Application No: AW/228/21/RES
Site Address: Rear of 34,36,38,40 & 44 Carlton Avenue Aldwick Bognor Regis PO21 3LR
Description of works: Approval of reserved matters following outline consent AW/130/18/OUT (layout, scale, landscape & appearance) for the erection of 8 No dwellings with access between 34 & 36 Carlton Avenue.

Thank you for your internet representation made on 27th July 2021 which has been recorded as an objection with the comments as follows:

DRAWING	007 UNIT 2/8 Floor Plans		
DATE	18 06 21		
AUTHOR	AH	REVISION	CORINTHIAN ARCHITECTURAL DESIGN Main Road, Fishbourne, Chichester, West Sussex. PO18 8BD 01243 576 078 > contact@corinthianad.co.uk > www.corinthianad.co.uk
STATUS	PL		
SCALE	1: 100 @ A3

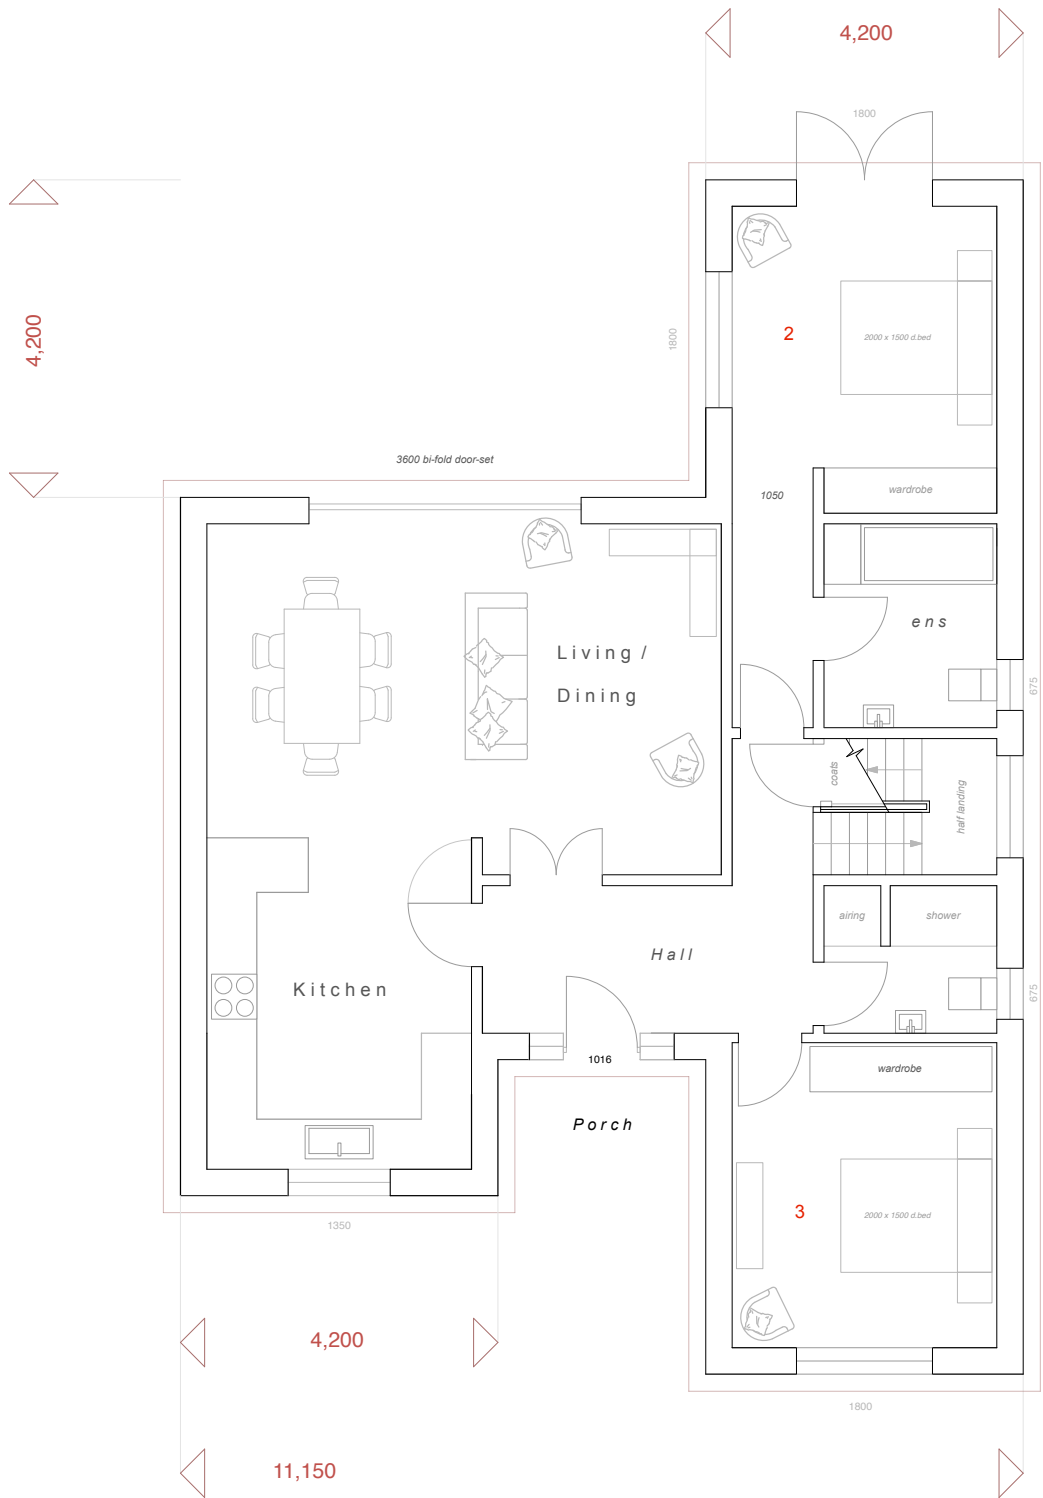
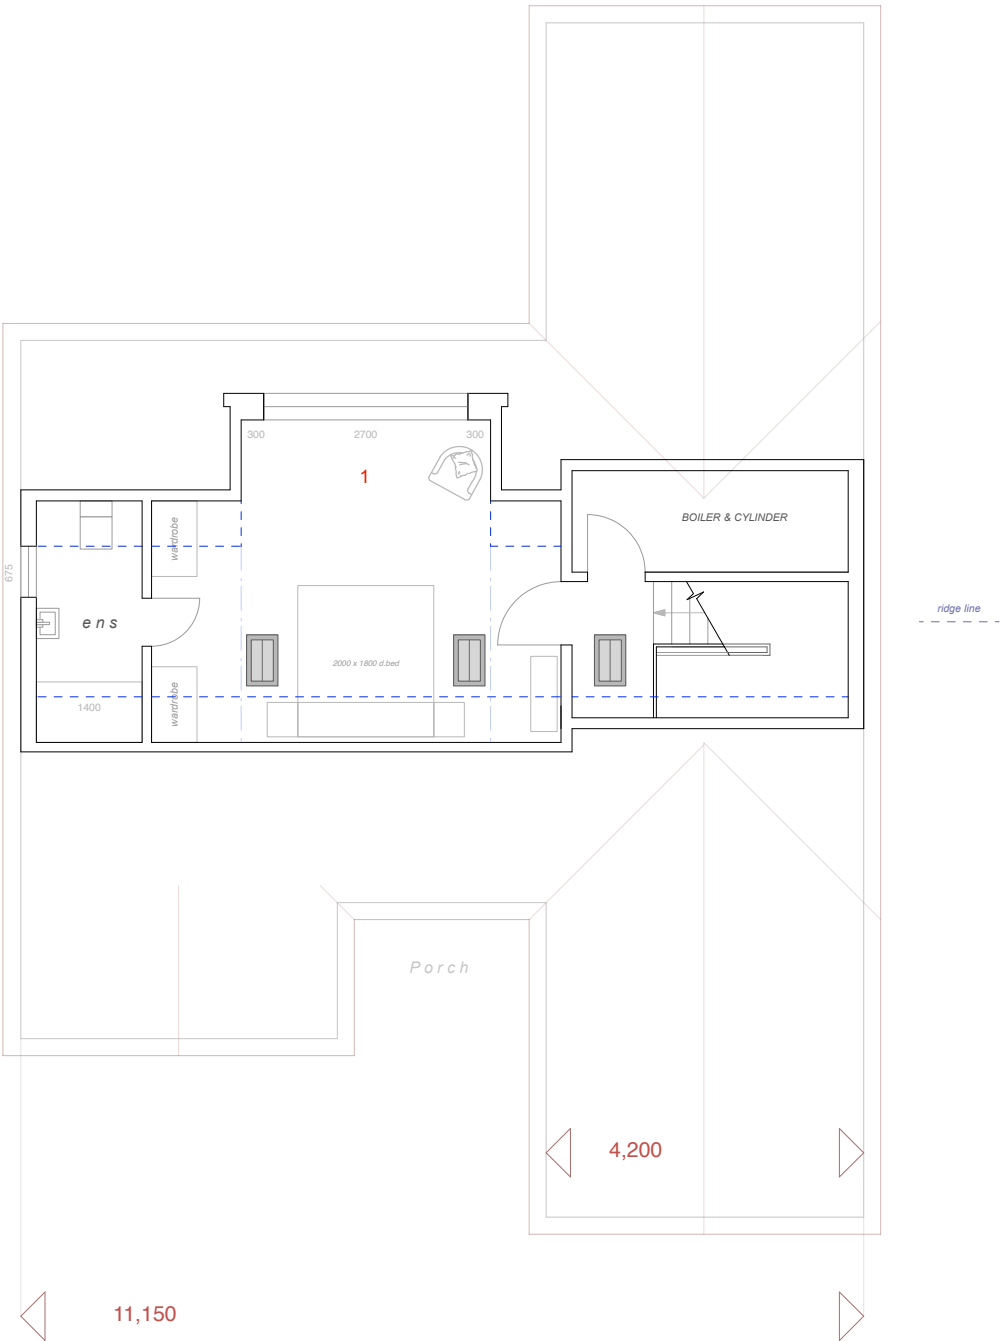
My main reason for writing is that I'm completely unhappy with the proposed building of no:2 which will have a direct impact on our view from our house, our kitchen & bedroom window view will be impacted. No.2 on the proposed plains will be in our direct sight, we use our front garden regularly and No.2 will be too close impacting on our quality of life.
